CITY OF ALBUQUERQUE

June 17, 2021

Re: Car Wash
7201 Wyoming Blvd NE 87109
30-Day Temporary Certificate of Occupancy
Transportation Development Final Inspection
Engineer's/Architect's Stamp dated 6-25-19 (D19D005)
Certification dated 5-5-21

SITE PLAN

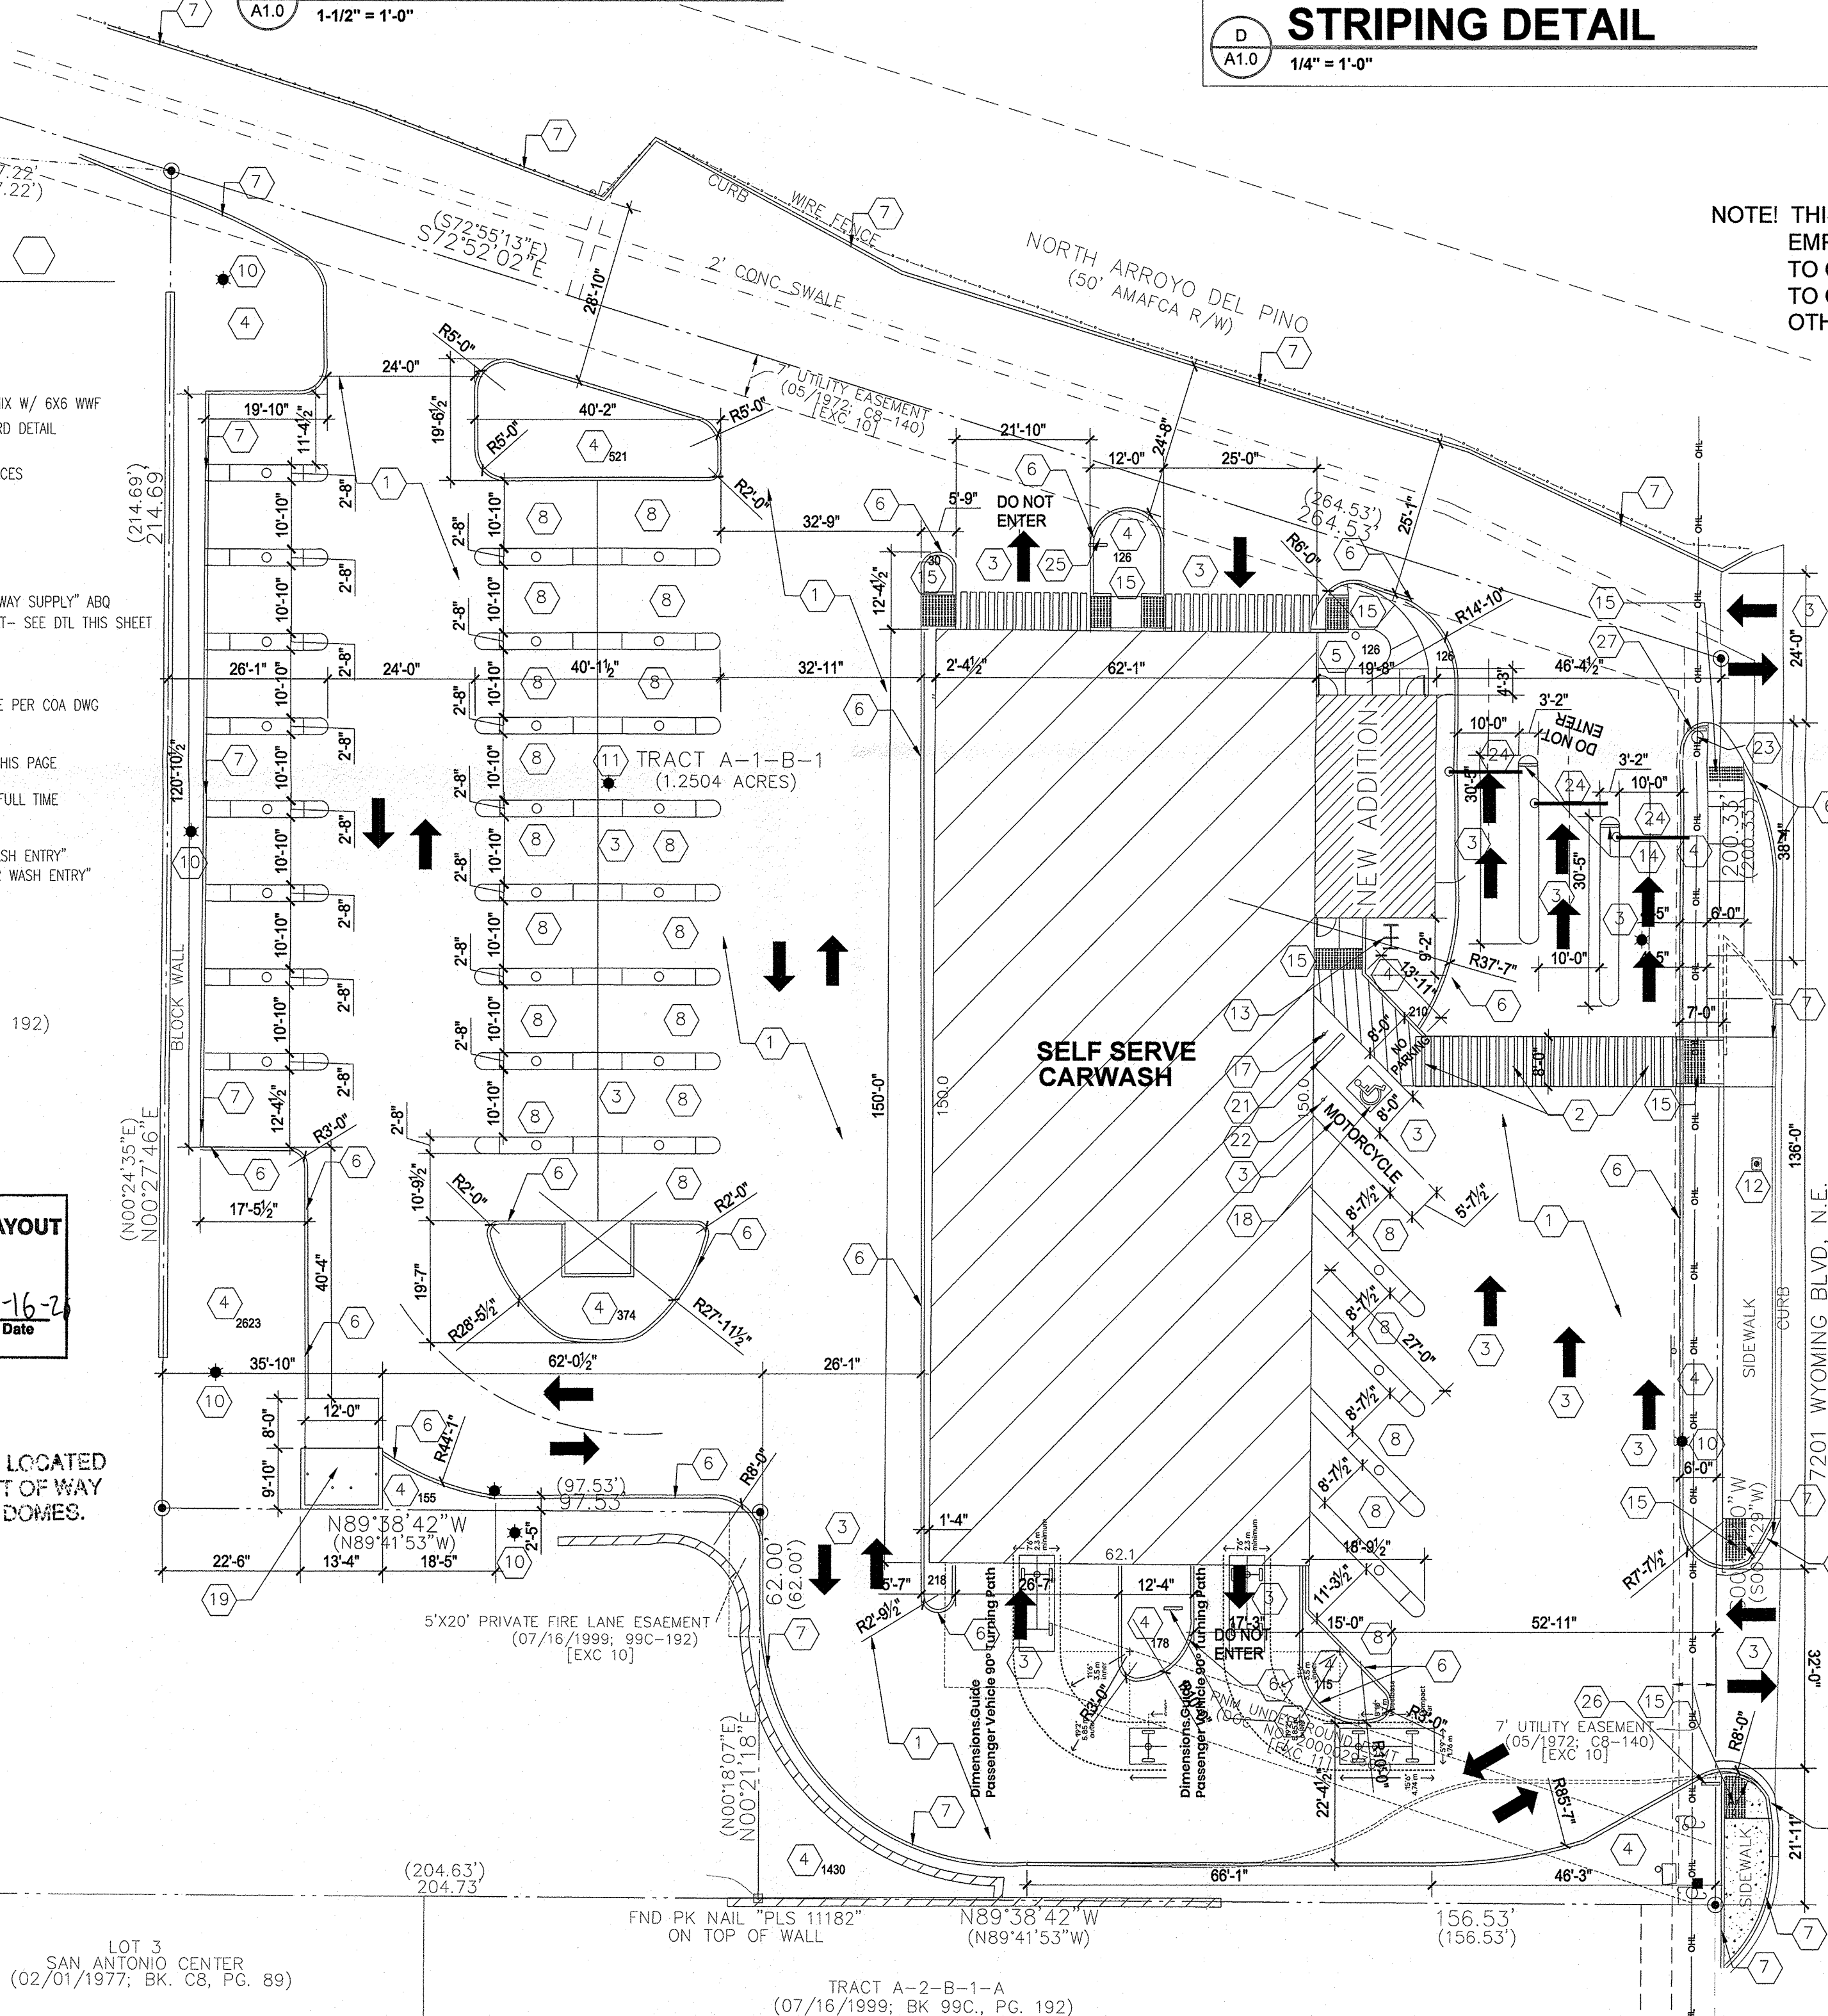
- The ADA accessible parking sign must have the required language per 66-7-352.4C NMSA 1978 "**Violators Are Subject to a Fine and/or Towing.**" Please call out detail and location of signs.
- Please add One Way Signs per approved TCL.
